From: Carol Reynolds
Sent: 02 July 2018 11:47
To: Planning.Responses
Subject: FW: Planning Consultation on LU/124/18/DOC

Environmental Health: I refer to The Noise Assessment Technical Report RFE-193-17-02 prepared by RF Environmental, March 2018, which is agreed in principal. I make the following comments upon The Draft Noise Management Plan here contained, which I would wish to be included in such a Management Plan and agreed with this Department before any grant of Discharge of Condition in this case.

APPLICATION LU/124/18/DOC

Registered: 27-APR-18
Site Address: 5 Selborne Place Selborne Road Littlehampton BN17 5NH
Description of Works: Approval of details reserved by condition imposed under LU/298/17/PL relating to conditions 3-Acoustic Report, 4-details of waste storage & 6-traffic & parking management details.

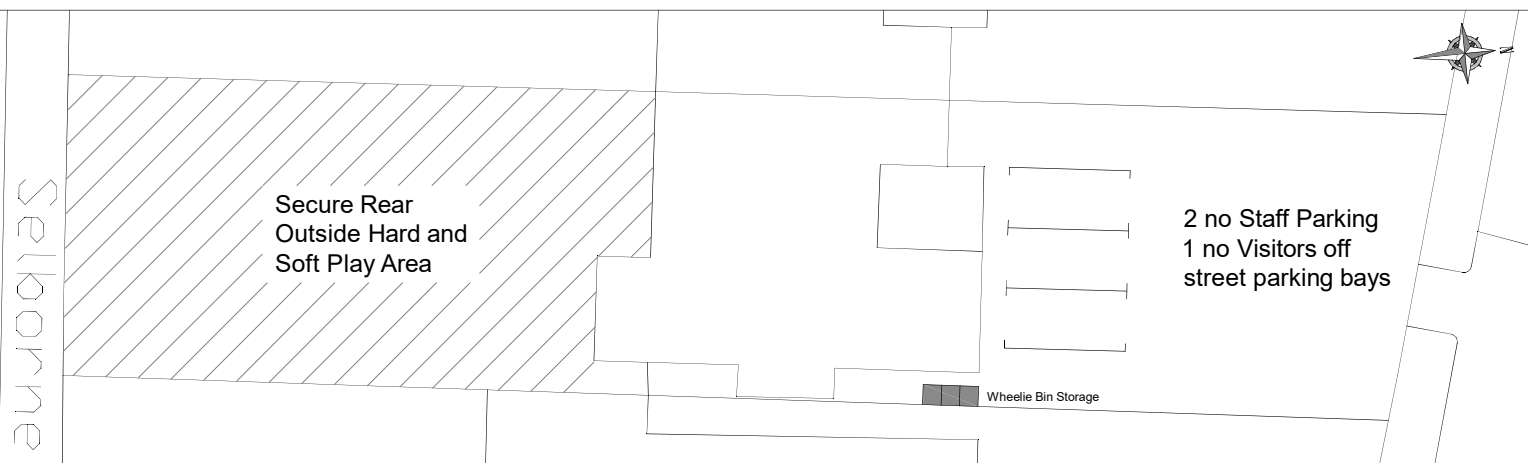
Please add the further requirement. Testing to be carried out by the noise consultant and reported to this Department within one month of operation of the facility at maximum capacity or thereabouts, to ensure that the Management System is being adhered to and that sound insulation provided to party walls is effective. The Layout of the premises to accord with Page 2, Paragraph 2.8 (quieter rooms against the party walls).
C/N: 224217
